File Name: ISH4 27th September Part 4.mp3
File Length: 01:52:28

Okay at the time is now 325. It's time to continue with issue specific hearing number four.

Thank you. Okay. So moving on to agenda item ten. Transportation and traffic. Item In relation to the traffic regulation measures,

Document Ref: EN010127/APP/2.7

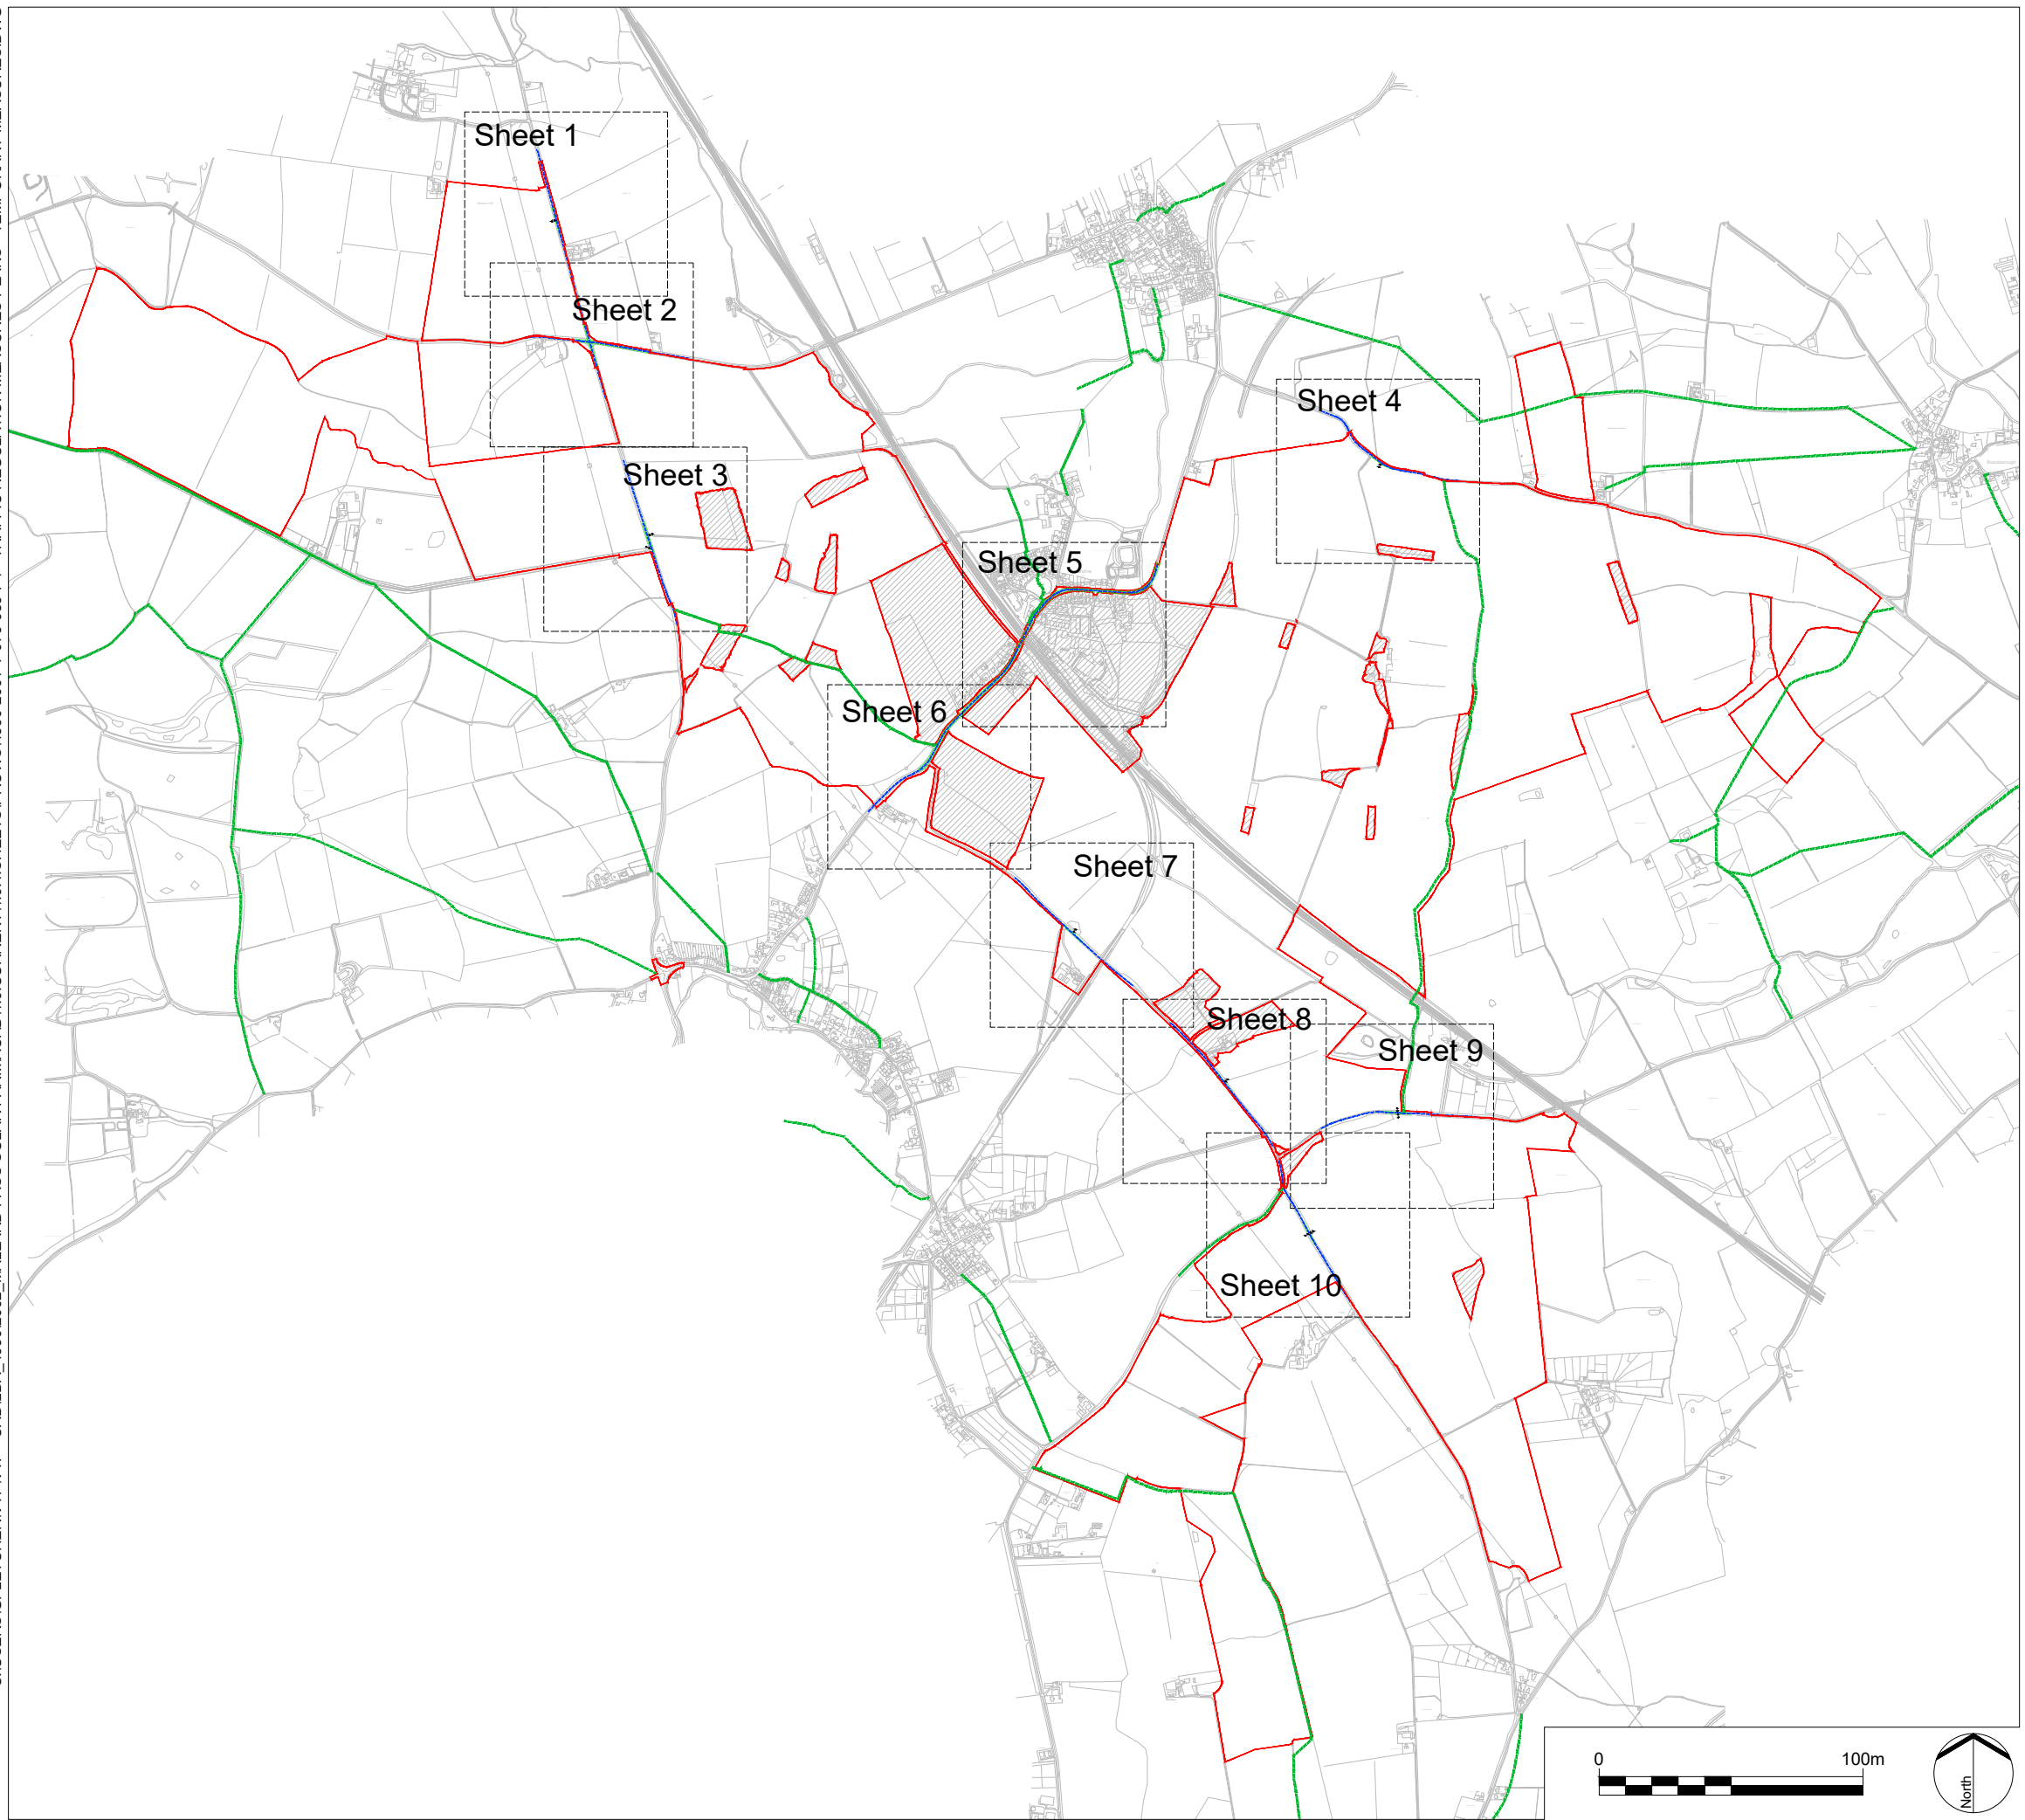
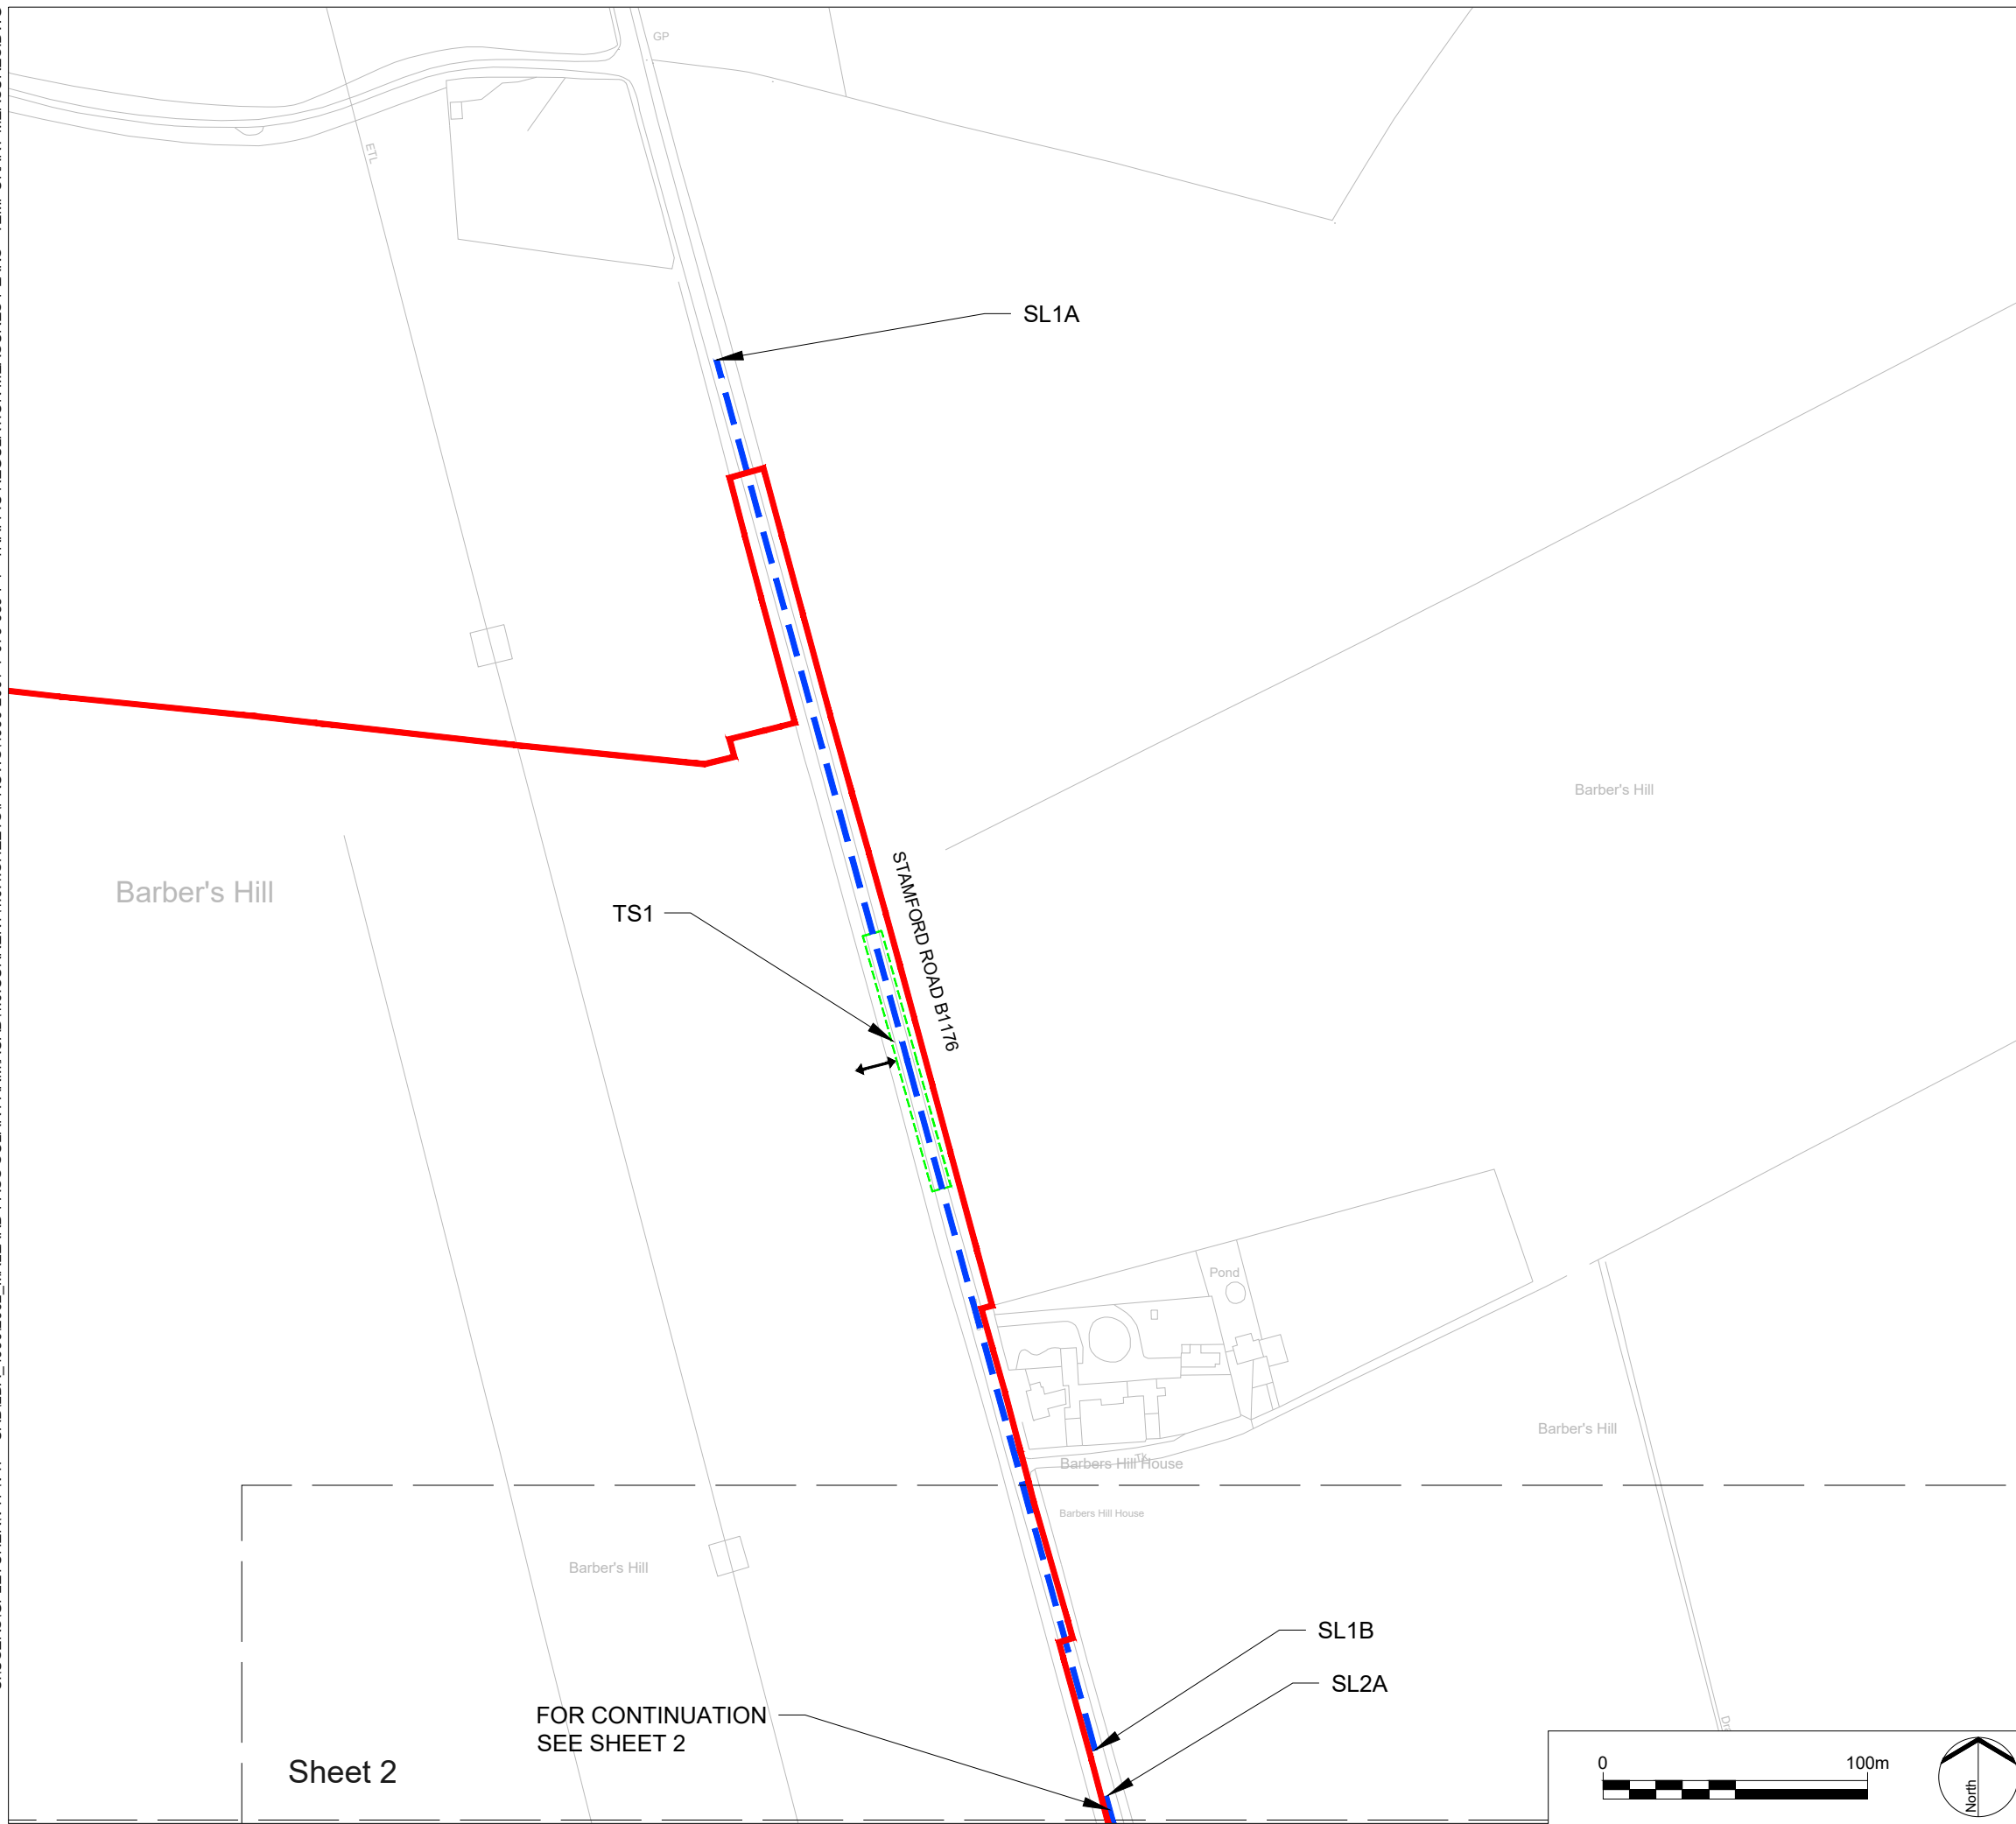
one in relation to the extends the temporary measures along Bond Road in S9. And just to point clarification in terms of the the of the proposed 30 mile an hour speed limit, which seems to replicate the existing 30mph speed limit through. Essendon. I don't know if they could. Perhaps just clarify that point. Also, note from the outline construction traffic management plan, paragraphs 4.7.1 and where it refers to a 20 mile an hour speed limits, whereas the other plans refer to a proposed 30,000,000 hour speed limits, which again, as I say, mirrors the speed limits already in existence through the village.

And it's the clarity that can be provided from that point. I think it's one of the concerns or issues that you raise being a point that could be quickly rectified earlier on in the day. So, Mr. Fox, if you could like to deal with that, please.

Yeah, I will bring Mr. Chancellor, But in my initial reaction is I think that is an error on the plans and they should read a 20 to be consistent with the TMP and the DCA. But I'll just get Mr. Ricky to confirm that.

Hi, everyone. Claudia Rich, on behalf of the applicant. Yeah. Believe that's a typo. We need to amend the plan.

To 20 miles an hour.
